# COUNTY COUNCIL'S RESPONSE TO CONSULTATION ON THE FOLLOWING DEVELOPMENT PROPOSAL

**Application no:** 24/02058/F

**Proposal:** Full application for the proposed erection of a two storey building to form a 66 no. bedroom care home for older people with parking, access, landscaping and associated ground works.

**Location:** Land to the North of Anniversary Avenue, Graven Hill , Bicester, OX25 2BF

TITLE
Drainage Strategy

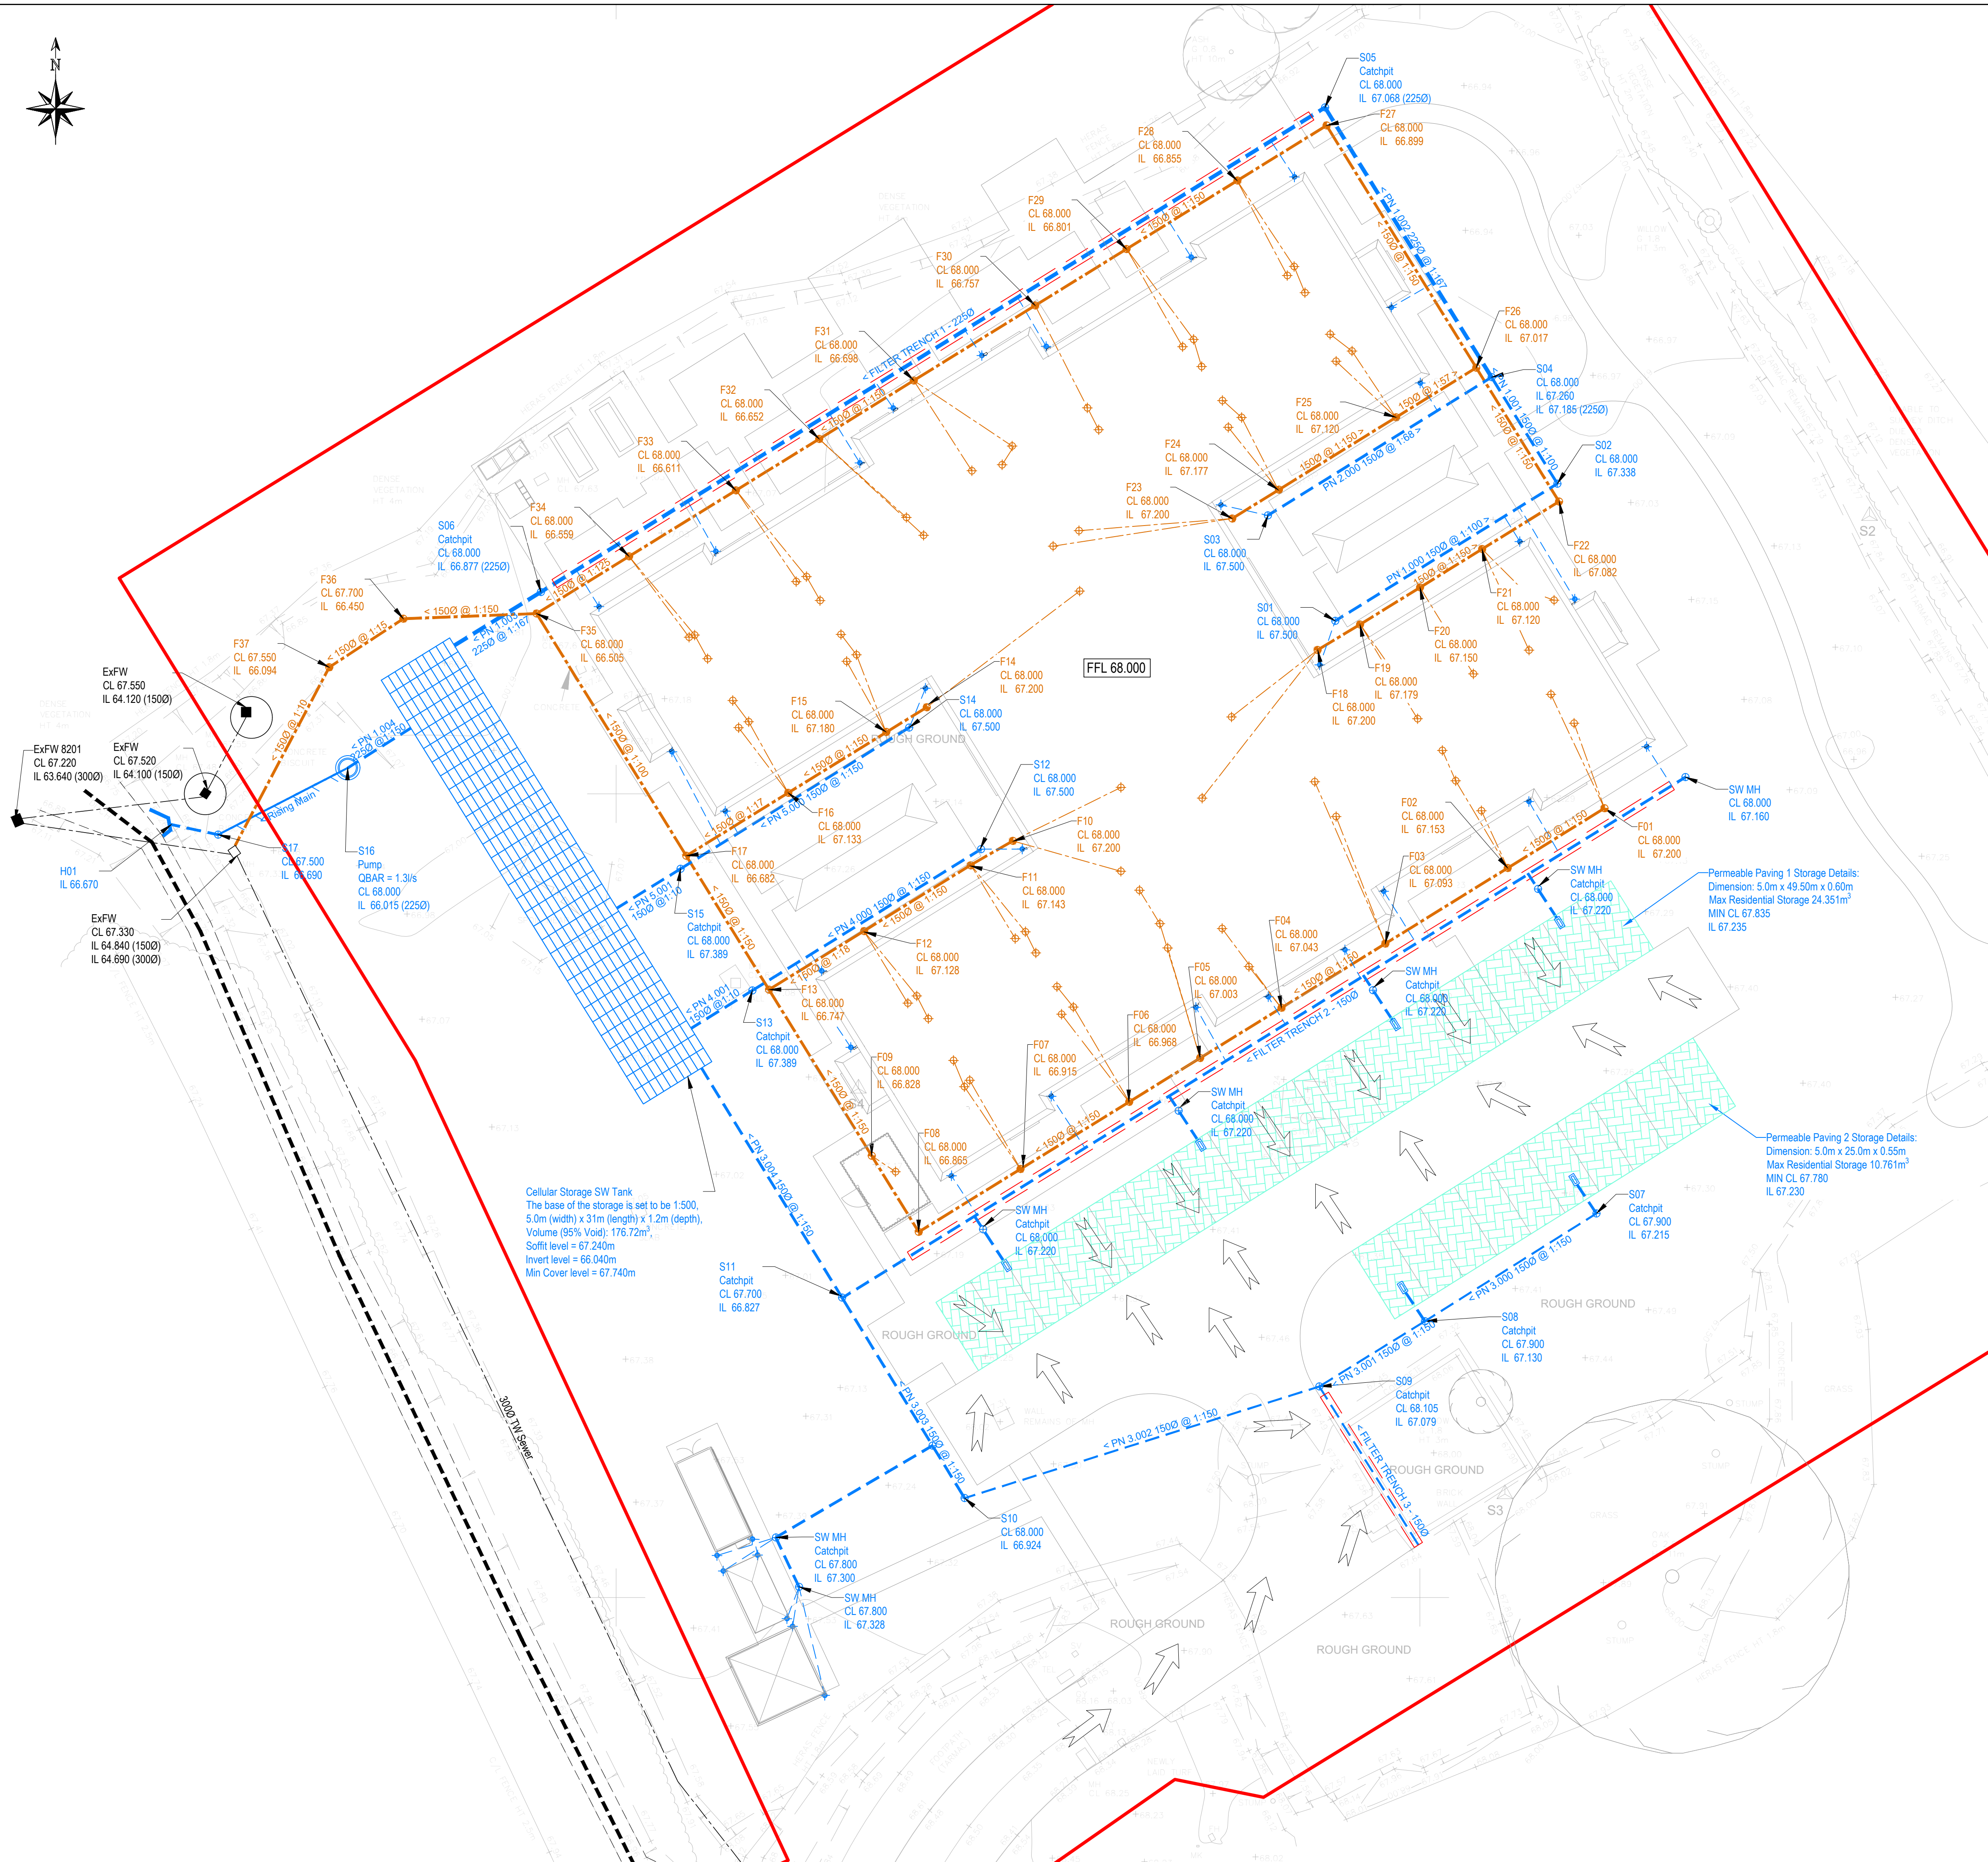
We need clarity on whether the whole site area has been used for calculating discharge rates for the wider site drainage strategy. Normally we would expect that the developable area is the area used for post-development runoff calculations. The defined catchments used for the wider site drainage strategy should be included and reviewed to ensure consistency.

Evidence will also be required of the 1 in 1 year discharge rate in the calculations.

The site area is 1.05 ha. The area to be drained appears to be 0.297 ha, and the proposed discharge rate for the 1 in 100 year storm event is 11.6 l/s. The discharge rate for the 1 in 2 year event is 6 l/s. No calculations have been provided for the 1 in 1 year event so it cannot be confirmed whether 2 l/s/ha is achieved.

The whole site area has been used for calculating discharge rates for the proposed development. Normally we would expect that the developable area is the area used for post-development runoff calculations. The catchment drawing CIV15119-C-SA-92-001 referred to in Appendix G of the FRA/Drainage Strategy may clarify this matter, so it would be useful to review it and confirm whether the proposed rates are being applied consistently.
